Your Ref :
Our Ref : BR/314/17/NMA

Section 96A of the Town & Country Planning Act 1990 (as amended)
Town and Country Planning (Development Management Procedure) (England) Order 2015 (as amended) - Article 10
Application for a non-material amendment following a grant of planning permission BR/71/12/
relating to amending Plot 1 to have the same gabled frontage as Plots 2 & 3
Brodict, 1 Castle Close, Bognor Regis,

Please note that Drawing 17-11-GD-203-03F-DA Rev A "Proposed Elevations" now forms part of the approved planning drawings and supersedes "Plot 1 Elevations" ref 2017/2/1 Rev A (Feb 2017).

Title
PROPOSED ELEVATIONS

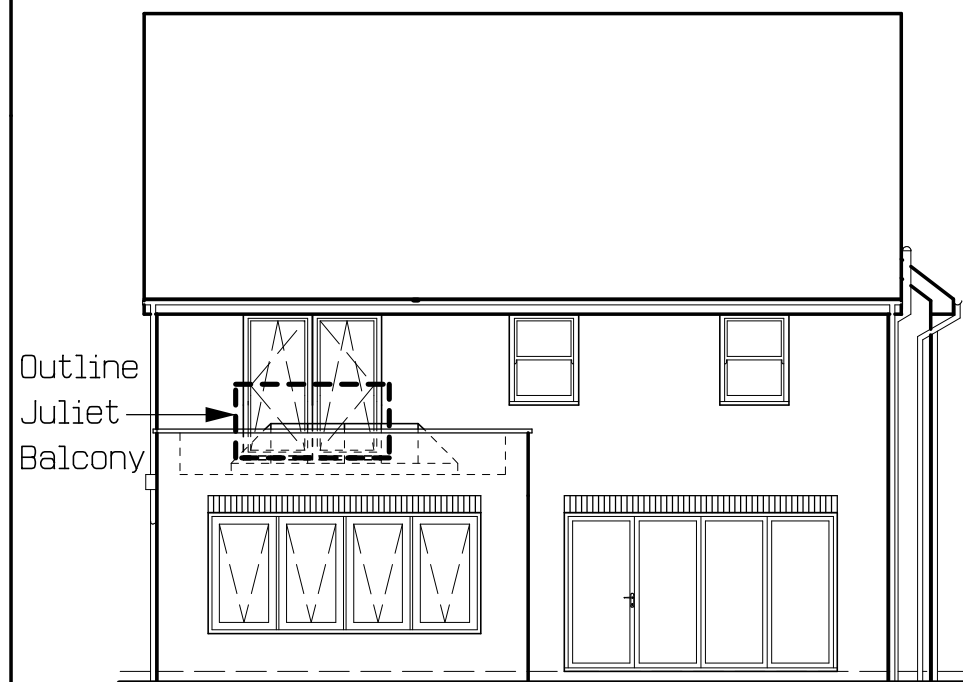
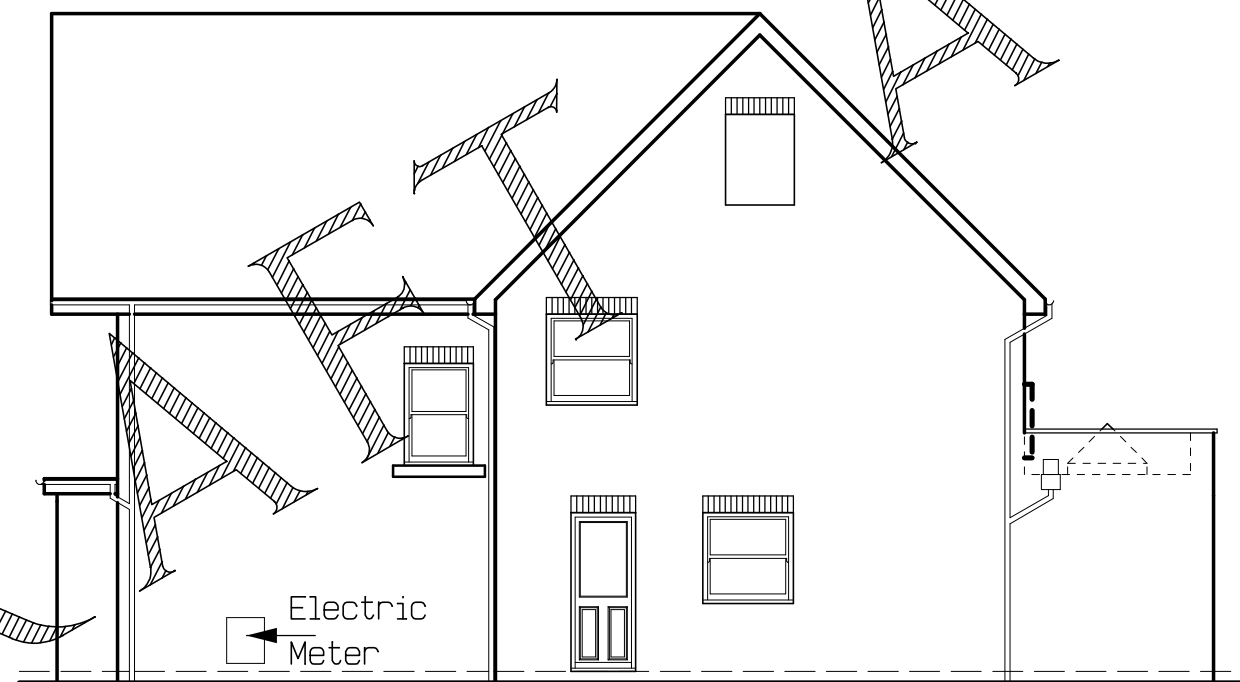
I refer to your recent application for a Non Material Minor Amendment. I note that you propose to change the roof of plot 1 from a front hipped arrangement to a front gabled arrangement to match plots 2 & 3.
